Developer Services
Southern Water
Sparrowgrove House
Sparrowgrove
Otterbourne
Hampshire
SO21 2SW

Your Ref
BE/117/18/DOC
Our Ref
PLAN-025547
Date
20/11/2018

Proposal: Application for approval of details reserved by conditions imposed on planning reference BE/18/17/PL relating to condition 5 (Surface water drainage), 6 (SUDs system), 14 (Foul drainage) & 23 (Vehicle access).
Site: Land off New Barn Lane, Bersted, PO21 5ED.
BE/117/18/DOC

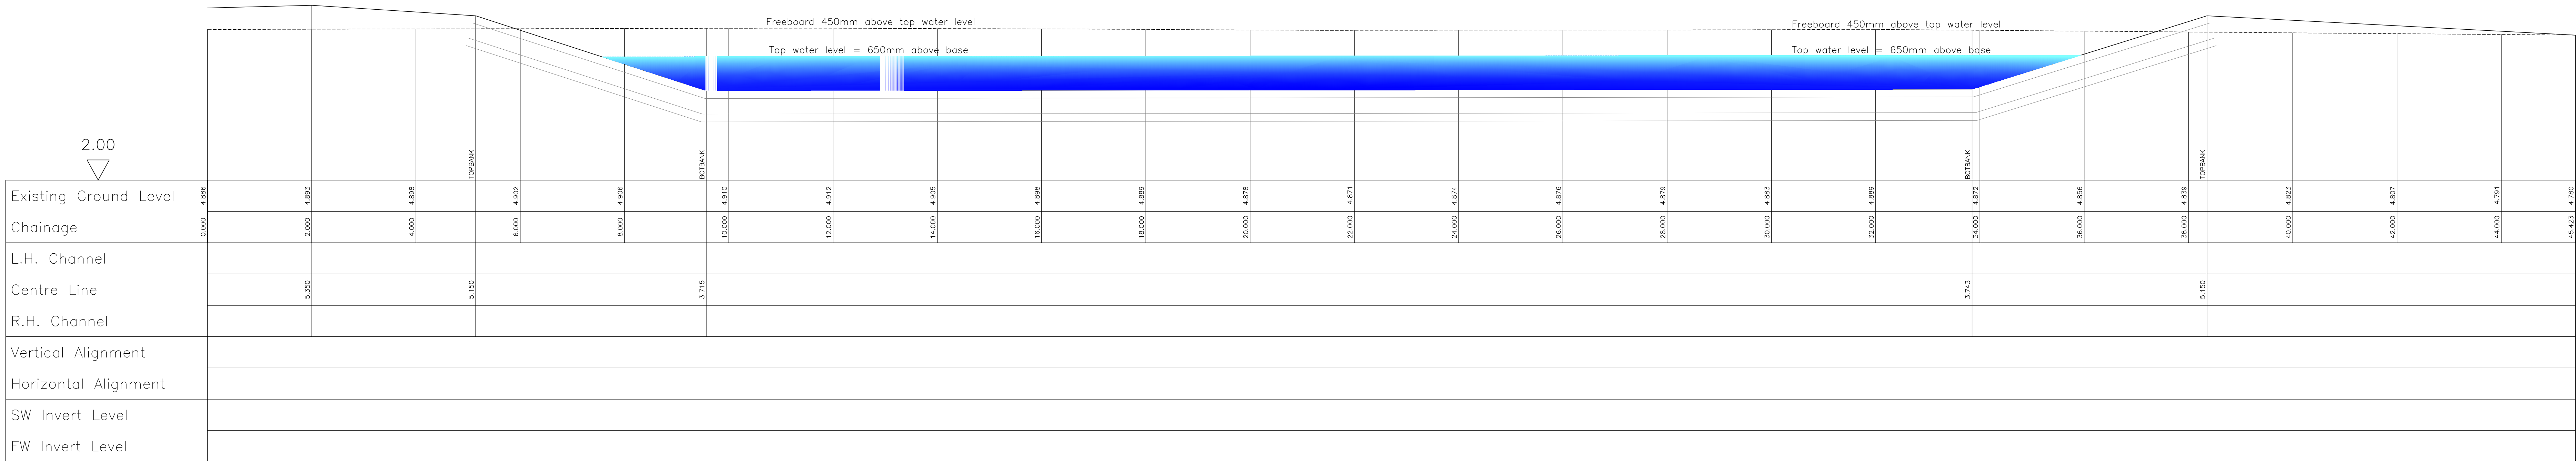
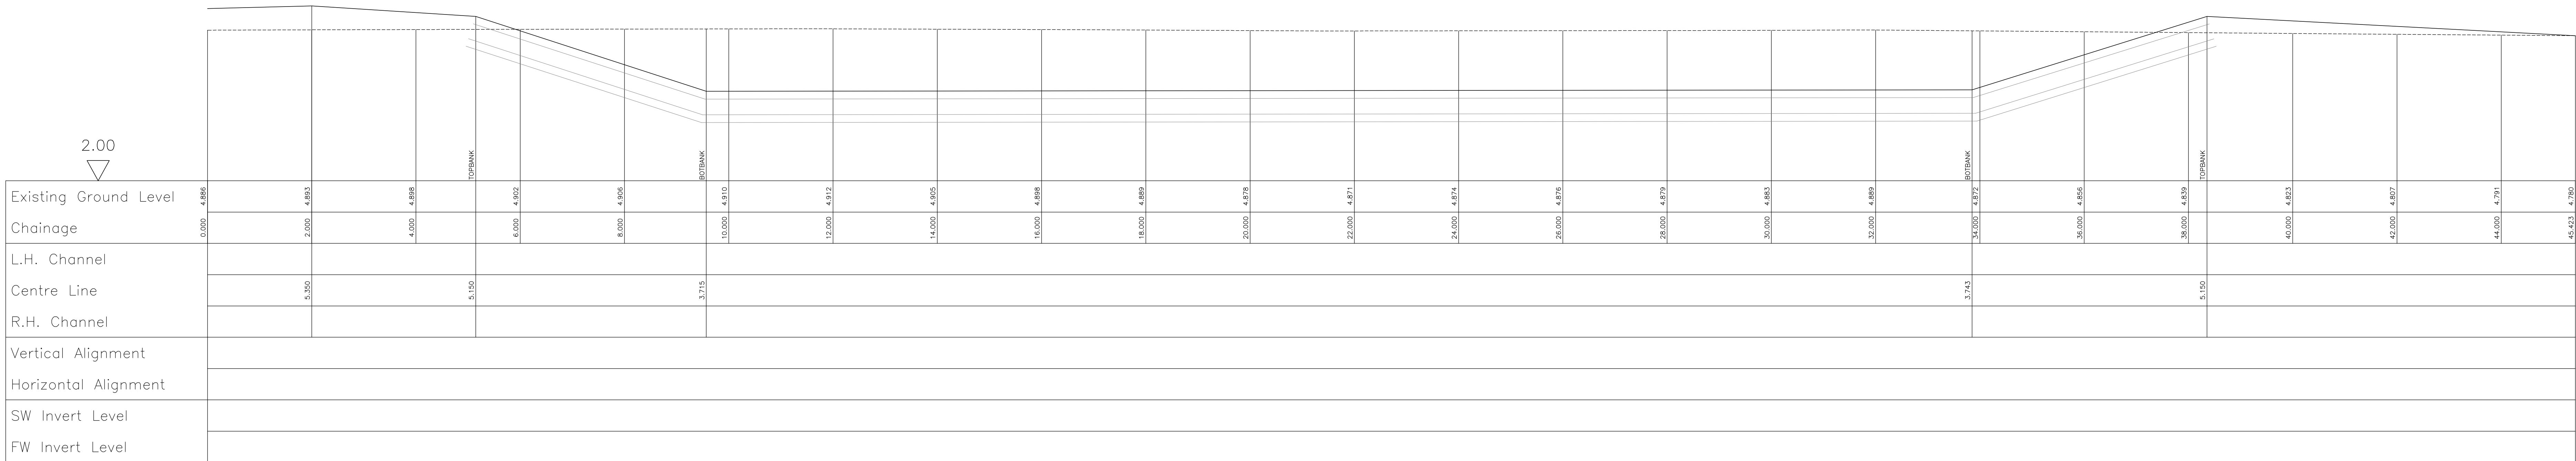
Under current legislation and guidance Sustainable Urban Drainage Systems (SUDS) rely upon facilities which Southern water does not adopt. No soakaways, swales, ponds, watercourses or any other surface water retaining or conveying features should be located within 5 metres of a public (also adoptable) sewers
